## WEST SUSSEX COUNTY COUNCIL CONSULTATION

| <b>LOCATION:</b>                | Land at Bilsham Road<br>Yapton                                                                                                                      |
| <b>SUBJECT:</b>                 | Y/13/22/DOC<br>Approval of details reserved by condition imposed under Y/91/17/OUT relating to condition -Construction Environment Management Plan. |

Bilsham Road, Yapton - Traffic Route Signage

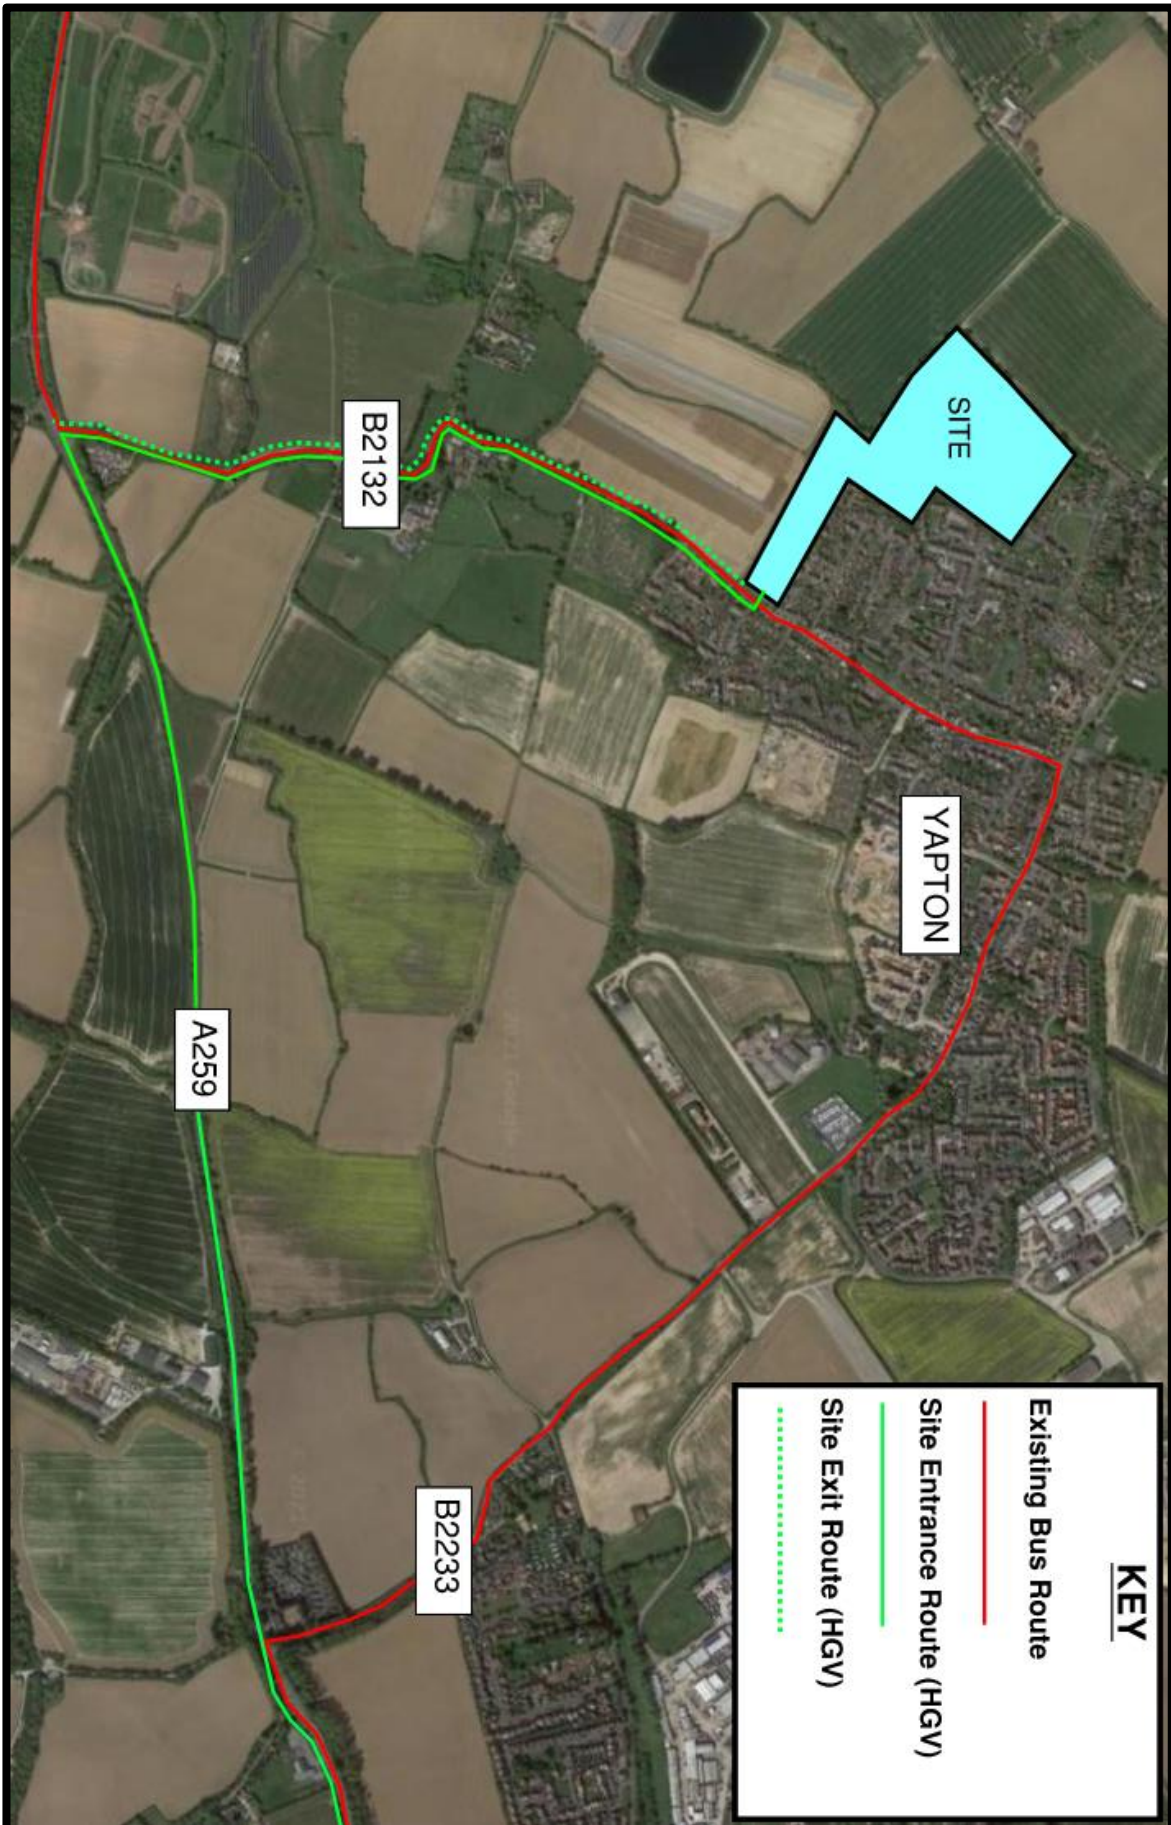
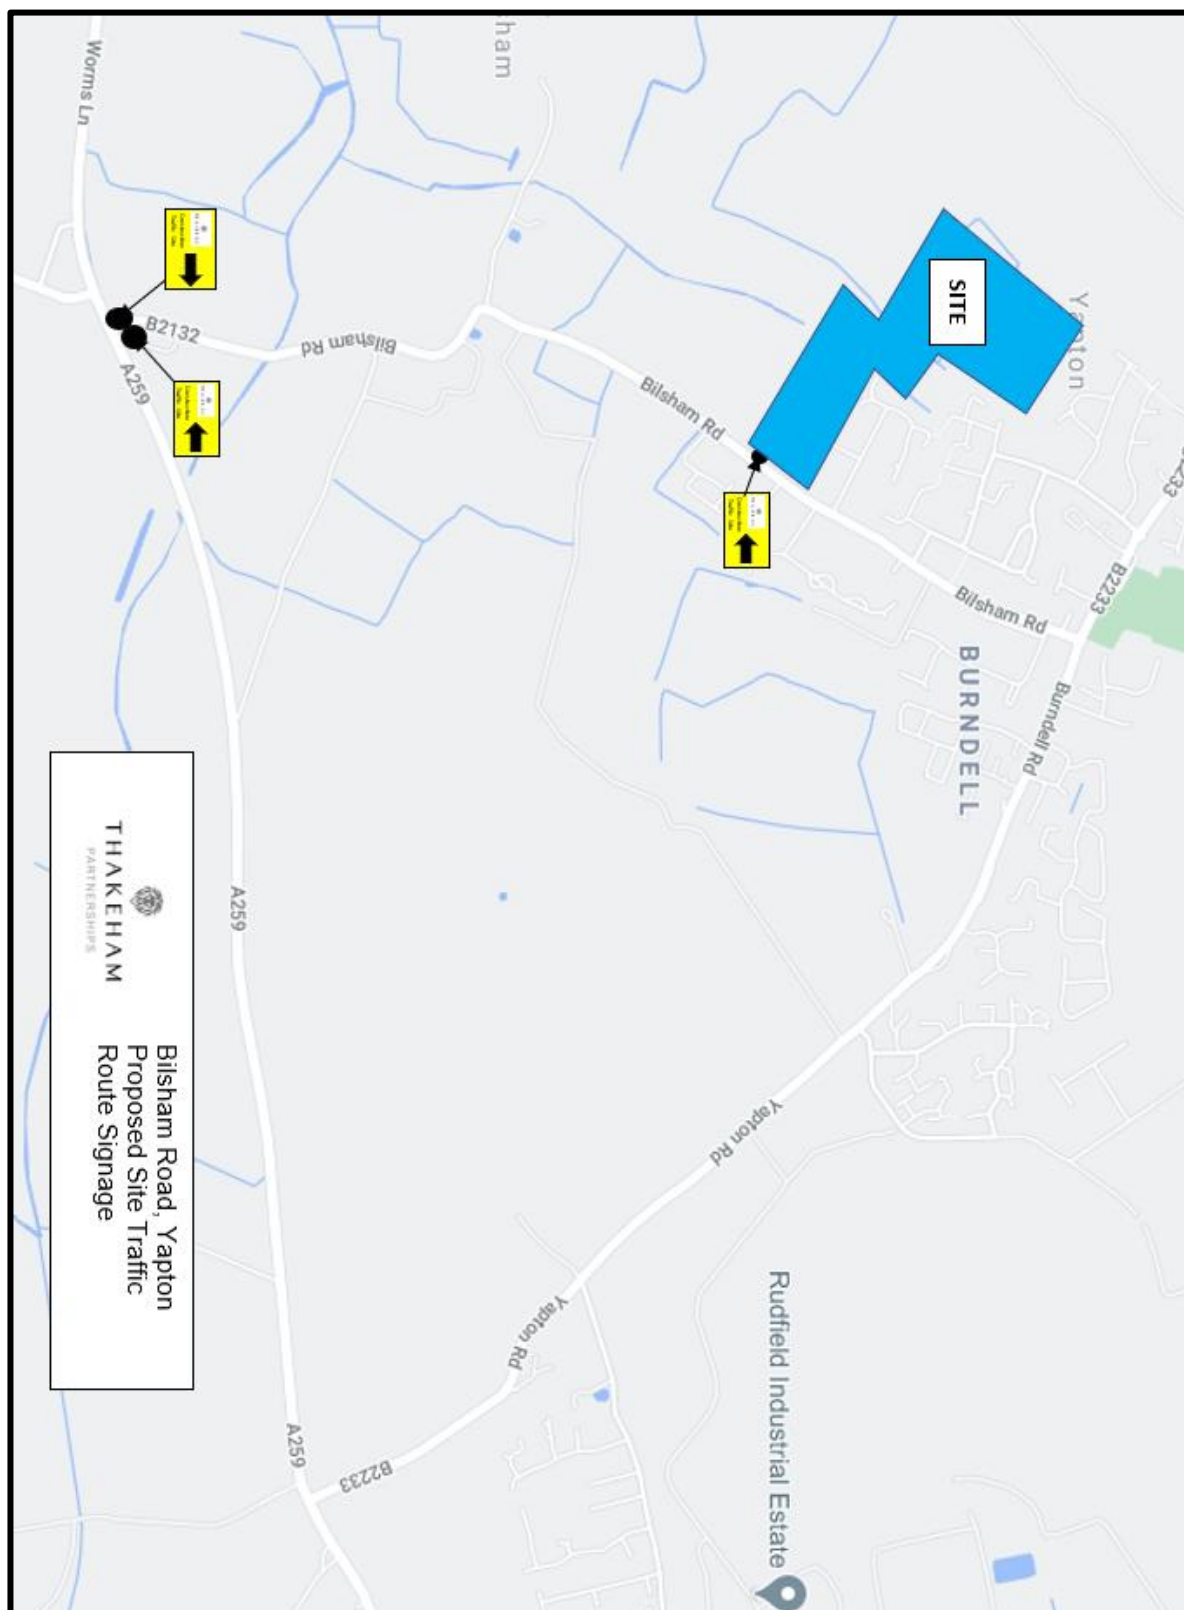
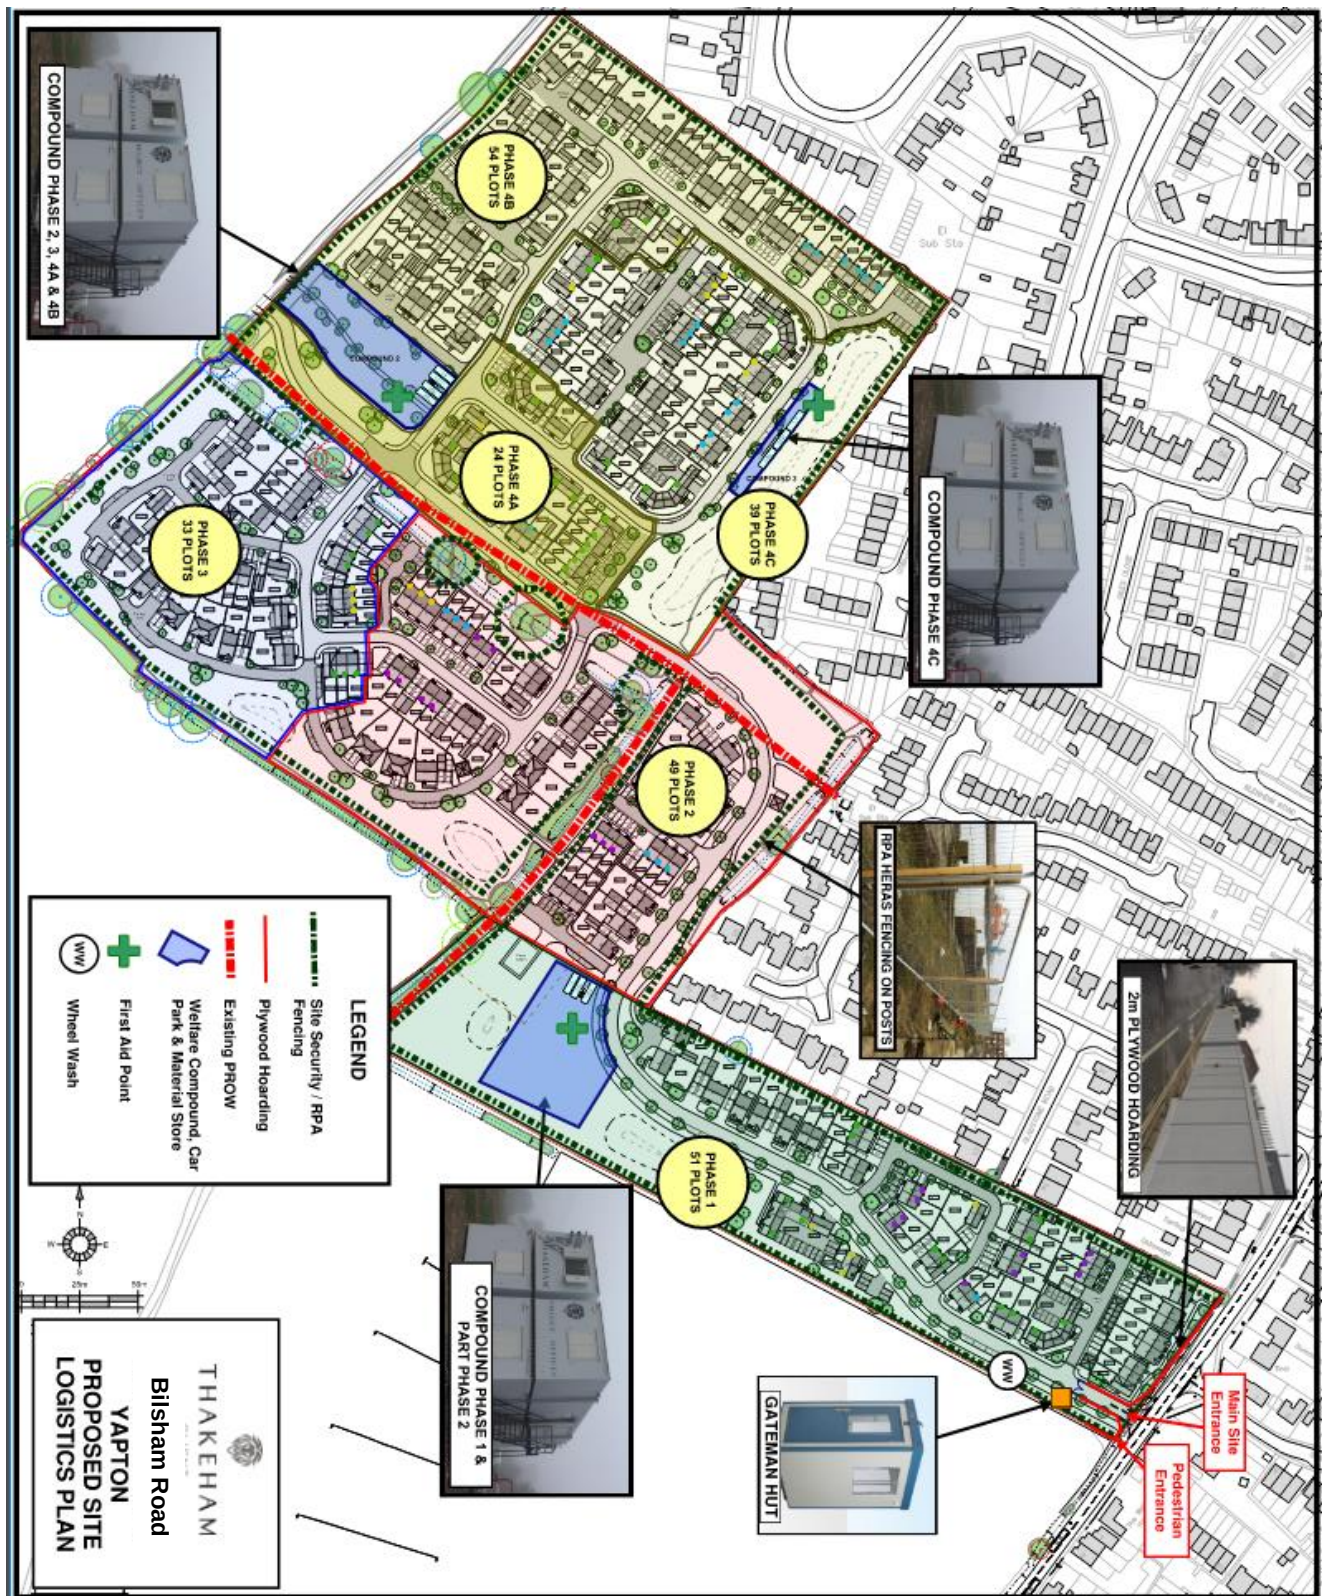
- In terms of the proposed construction routing to the site, the submitted routing plans on pages 31 and 32 of the CEMP are not legible and it is not clear as to what is proposed. From the text within the CEMP it appears that the intention is that vehicles shall access the site from the Oystercatcher junction on the A259 and use Yapton Road (B2233) before turning left onto Bilsham Road (B2132) and then turning right into the site to access the site. Vehicles leaving the site are proposed to turn right out the site and head southbound towards Comet Corner on the A259.

The Highway Authority have no objections with the proposed routing for vehicles leaving the site. However, It is not apparent as to the rational for vehicles entering the site to take a different route. Therefore consideration should be given as to why vehicles accessing the site

cannot make use of Comet Corner either turning left or right from the A259 and heading northbound on Bilsham Road (B2132) before turning left into the site. This route would appear to be keep construction vehicles on A classified roads for longer periods of time, reduce the potential likelihood of HGVs interacting with more vulnerable road users and reduce the time construction vehicles would spend on roads of a more residential nature. Consideration should be given to amending the construction traffic route or further rational as to why it is proposed to access the site in the way currently proposed.
